SUBJECT: Engineering Review Comment
Mountain View Electric Association Inc. (MVEA)

Project Name: Rolling Hills Ranch North Filing 2 – Final Plat

Project Number: SF2424

# ROLLING HILLS RANCH NORTH FILING NO. 2 AT MERIDIAN RANCH

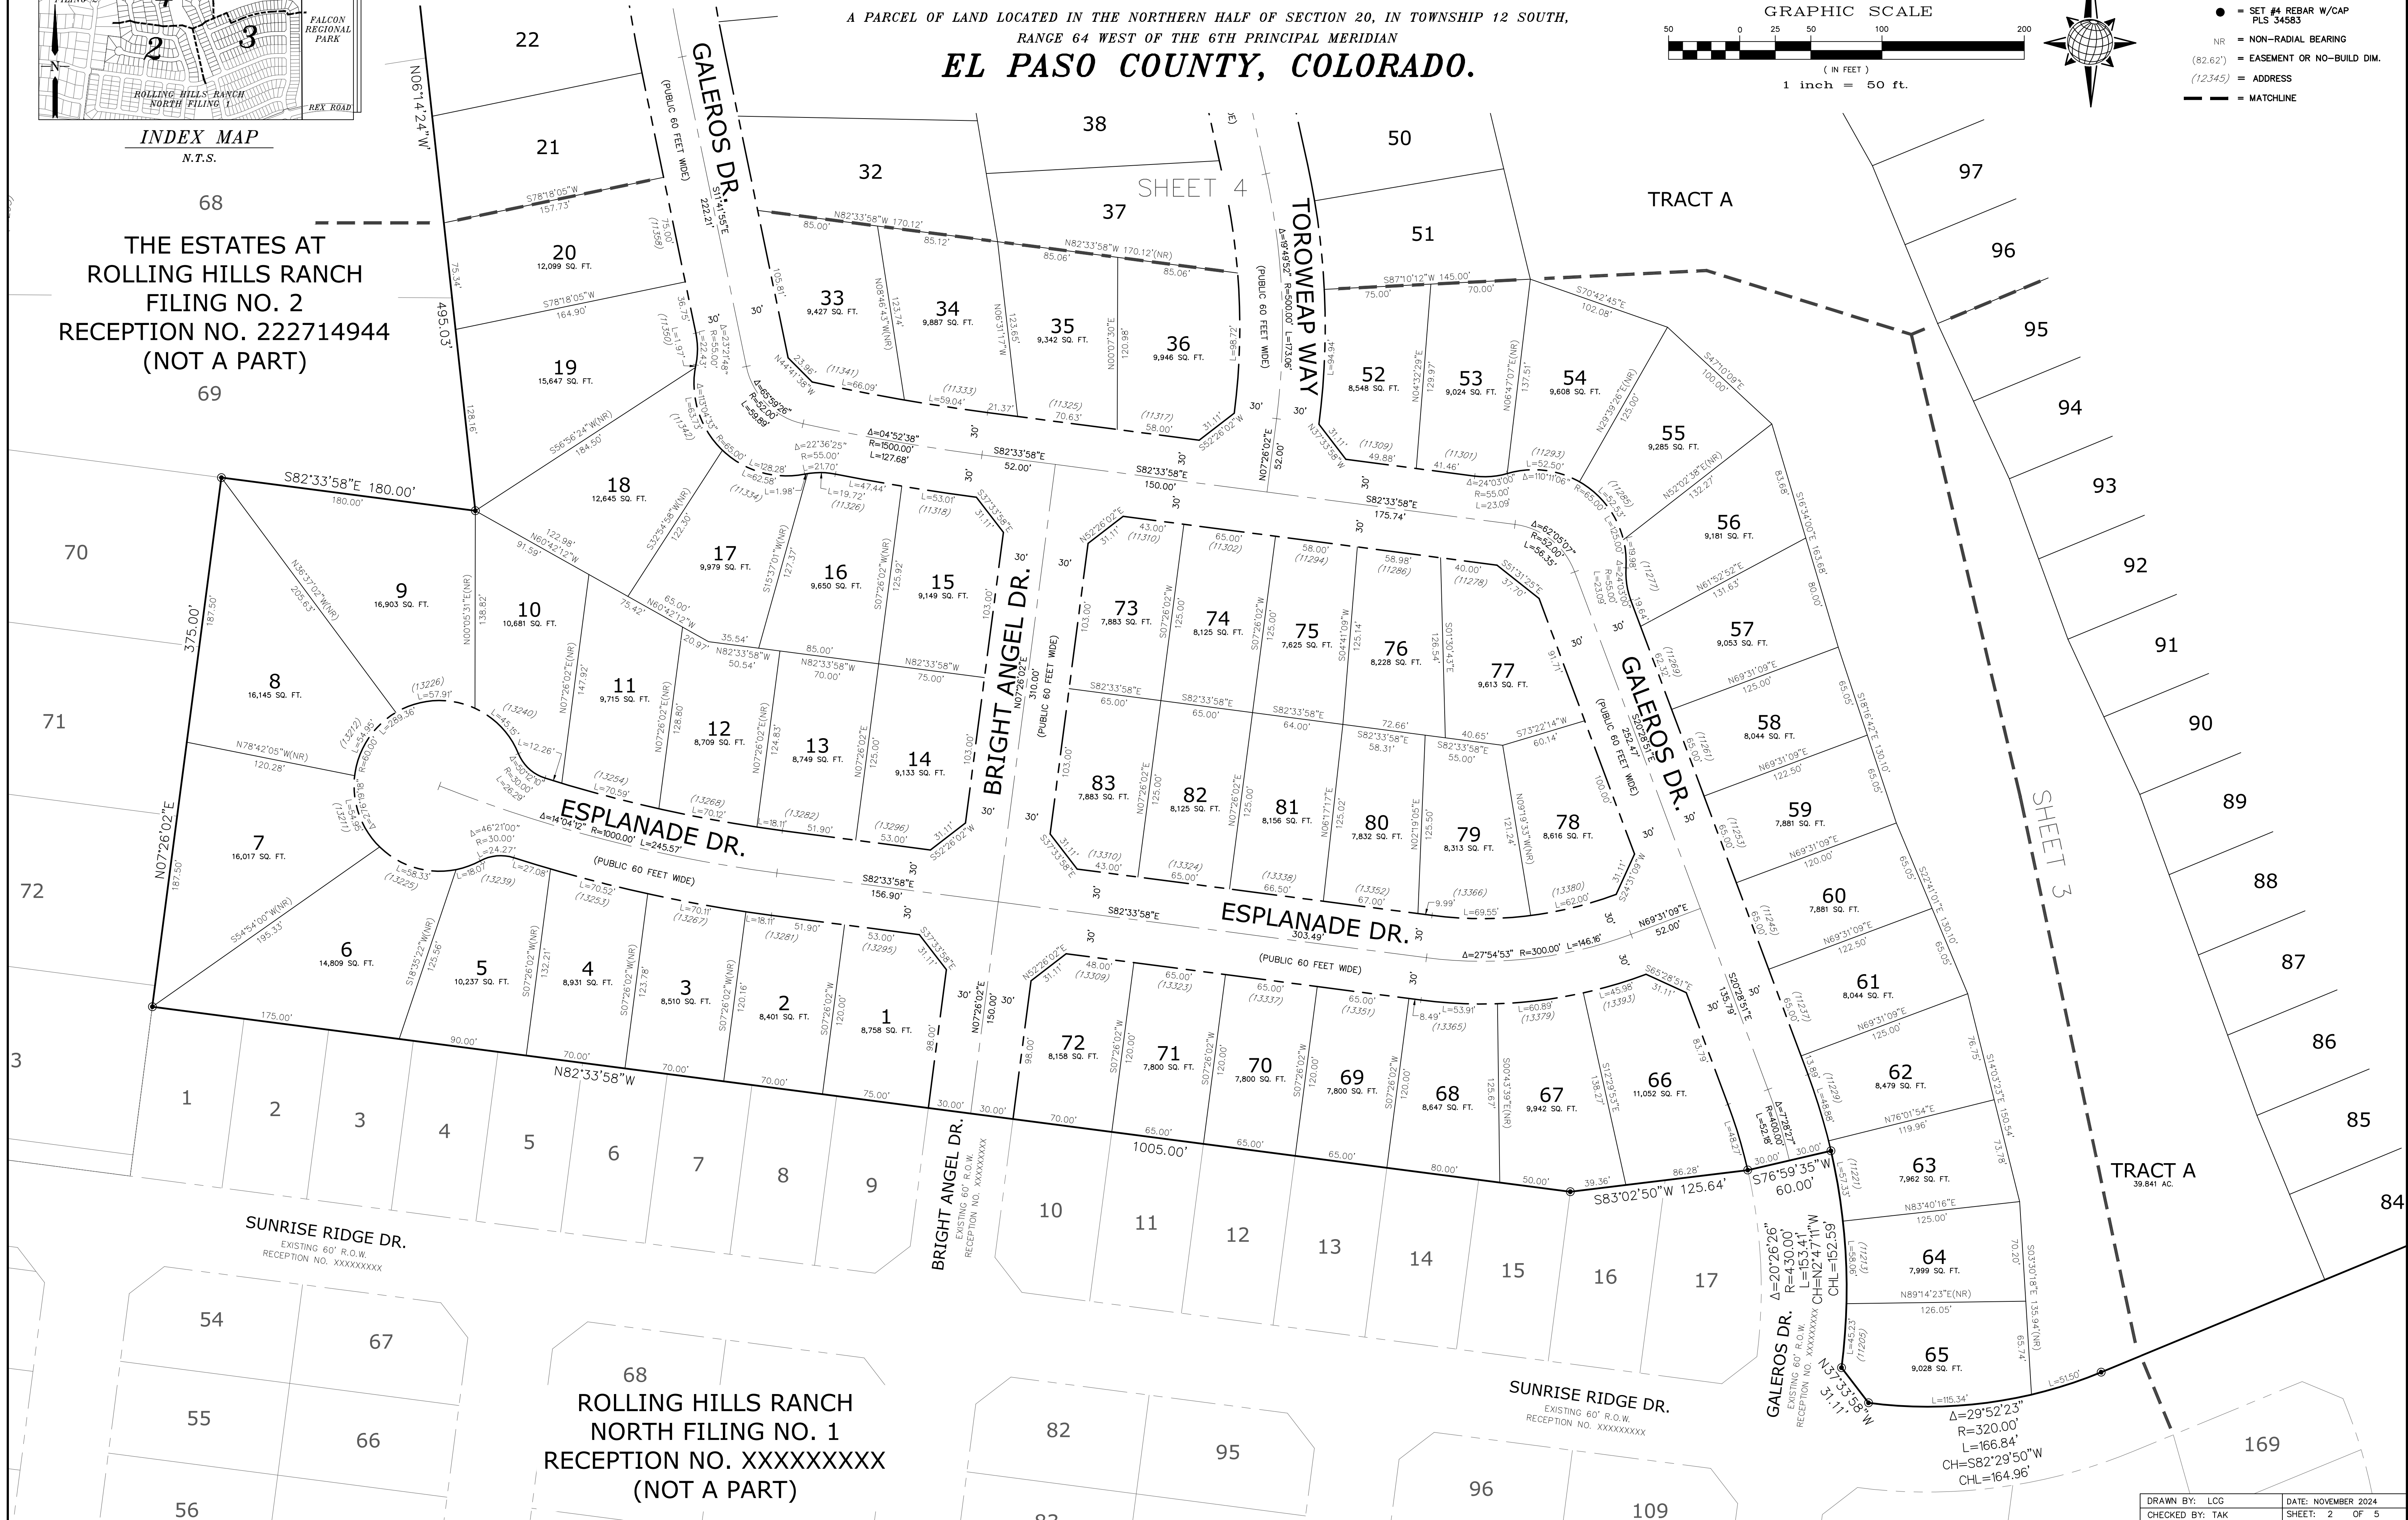
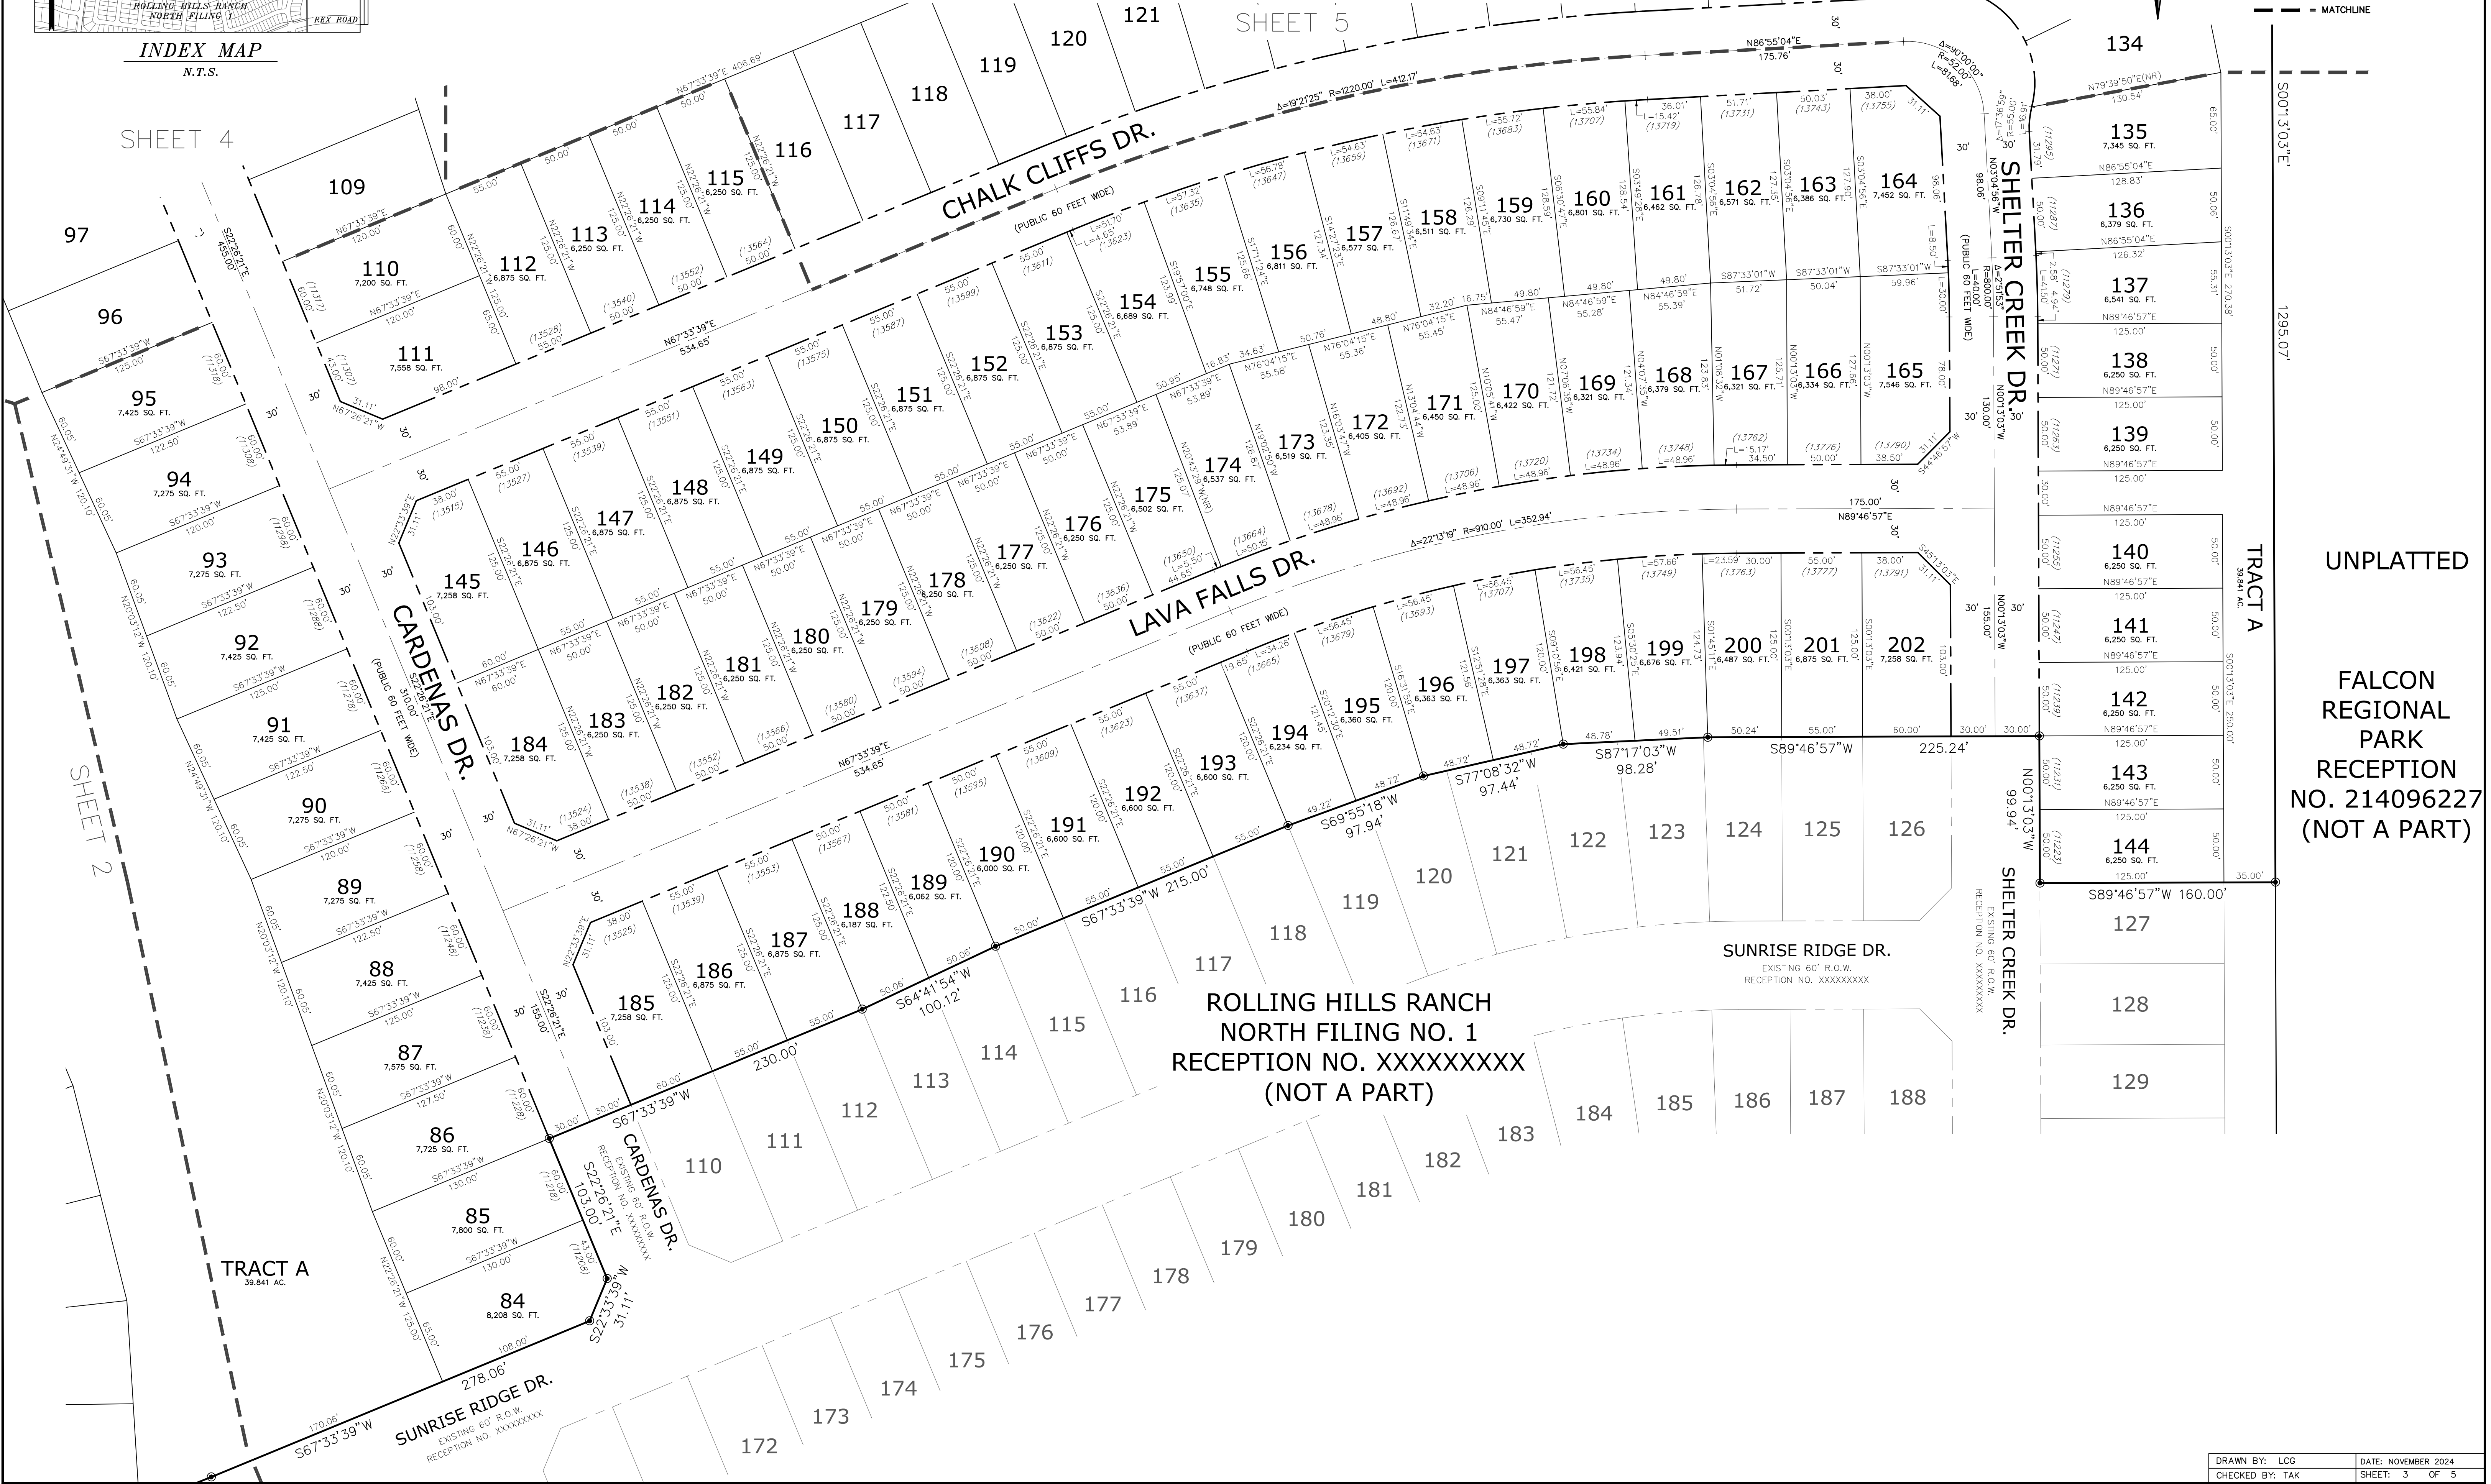
MVEA requests a ten (10) foot front lot utility easement, a five (5) foot side lot utility easement, and a seven and a half (7.5) foot rear lot utility easement along with a twenty (20) foot exterior utility easement on the plat and all tracts include easements. MVEA also requests the platting of MVEA's existing facilities with easements on the plat. Additional easements may be required.

MVEA has existing facilities near and within this parcel of land. If there is any damage, removal or relocation of facilities it will be at the expense of the applicant.
